PHOTOMETRIC DETAILS

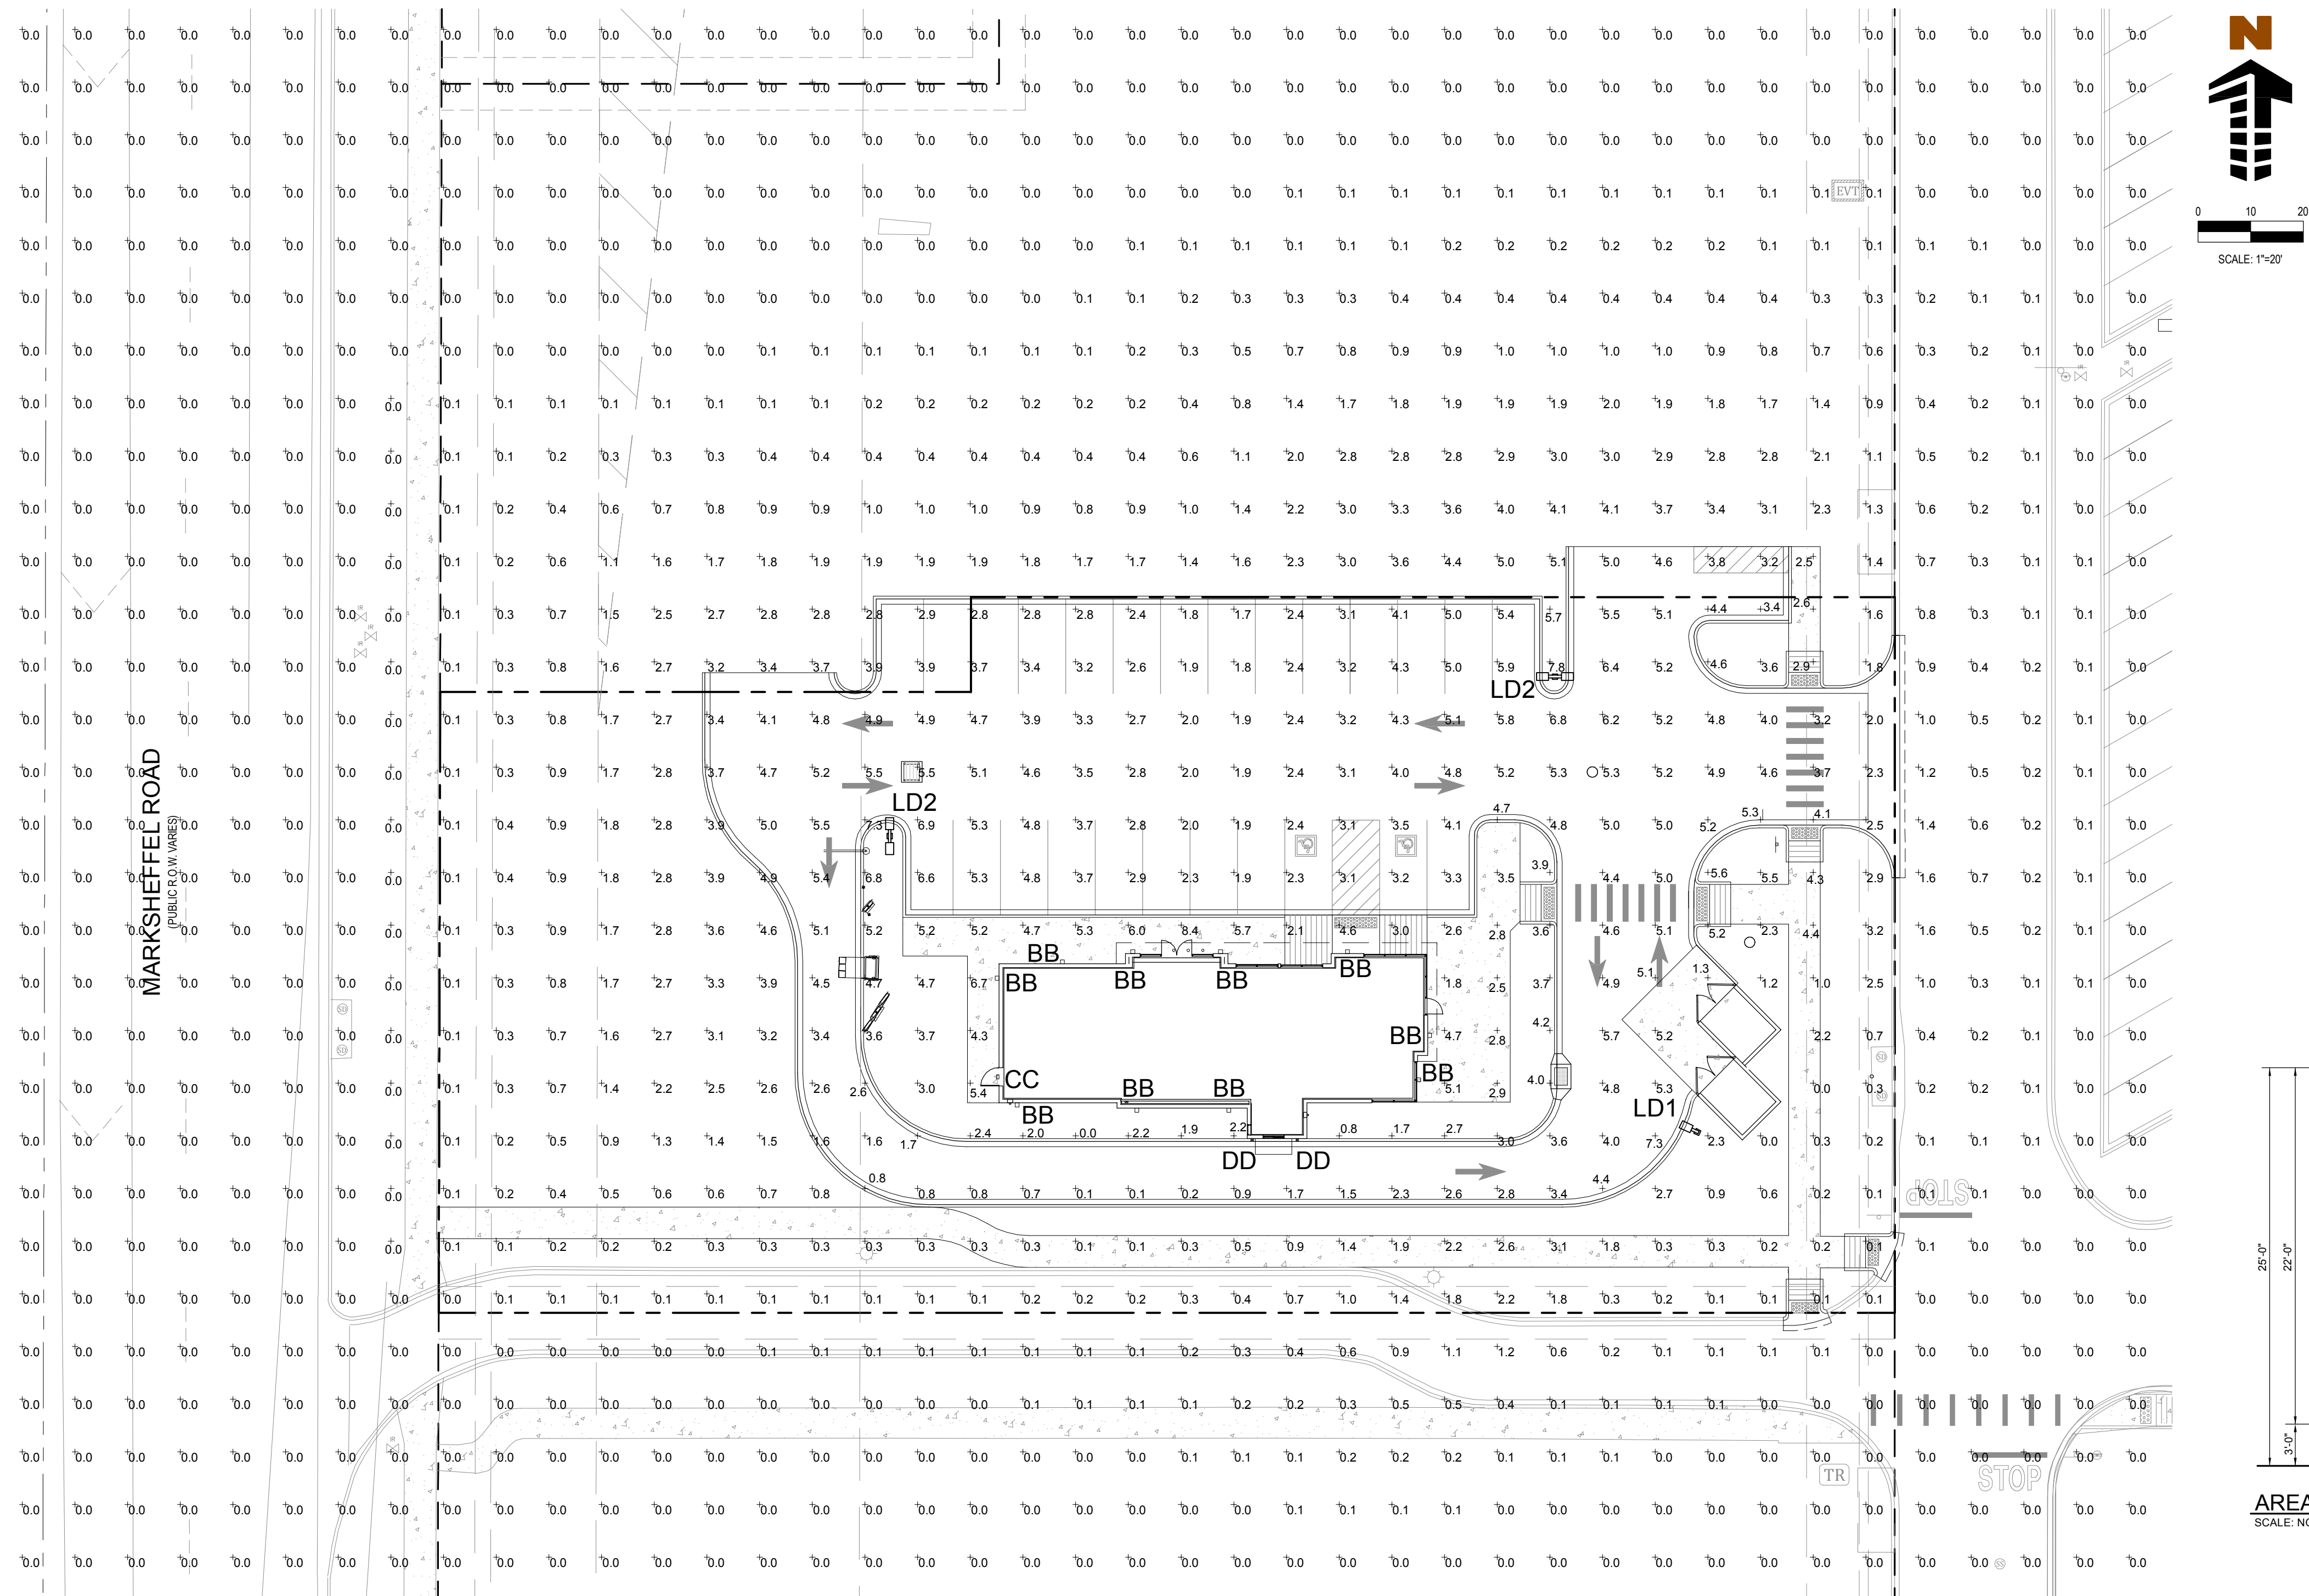
Alternative Lighting Plan request addressed in LOI, Director approval required, his comments are that the Foot Candles need to be addressed before he can grant approval.

Per 6.2.3 Lighting (e) Light levels measured at the property line of the development site adjacent to residential property or public right of way shall not exceed 0.1 foot candles as a direct result of the on-site lighting.
